Your Ref: OWPC15603
Our Ref: M/71/17/HH 21-07-2017
Please ask for:
Mr D Easton

Two storey side extension with 2 No. dormers to front elevation.
Little Thatch 93 Middleton Road Middleton on Sea

SITE PLAN

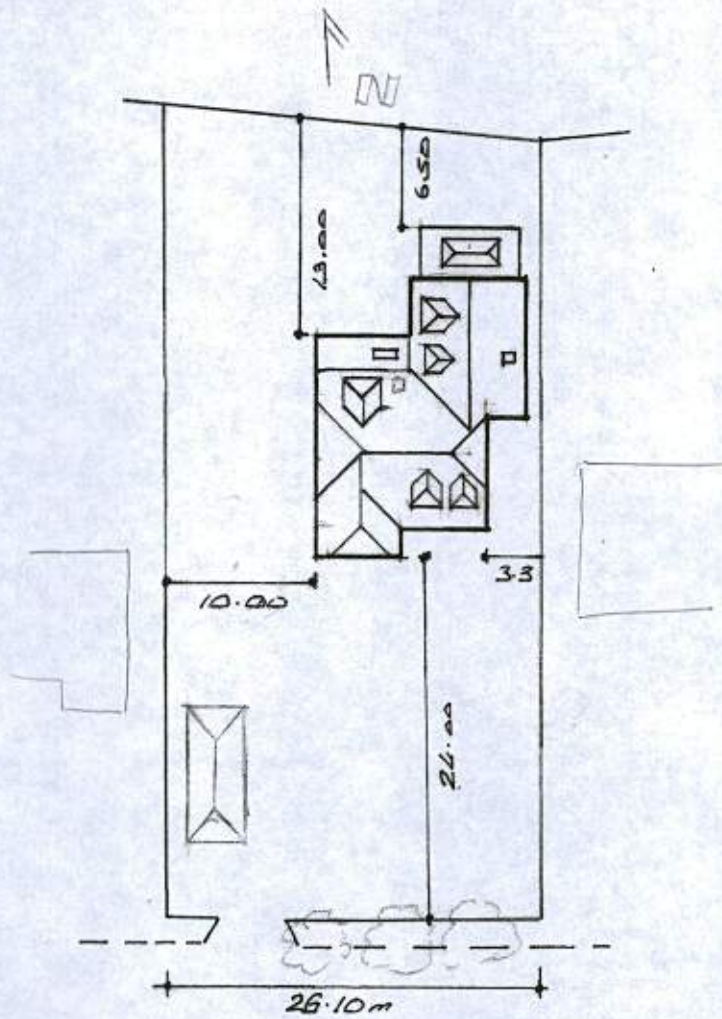
Continuation of previous comments : The rear part of the house is to have a new front door on the southern edge of the annex. We are concerned that this is so close to our boundary and babies bedroom. The potential for increased foot traffic, automatic sensor lighting, door bells and increased noise from greetings and farewells is a particular concern.

The current annex is extremely close to the boundary, possibly less than a metre at its southern edge. Increasing the height so dramatically will only increase the feeling of being loomed over by a large building.
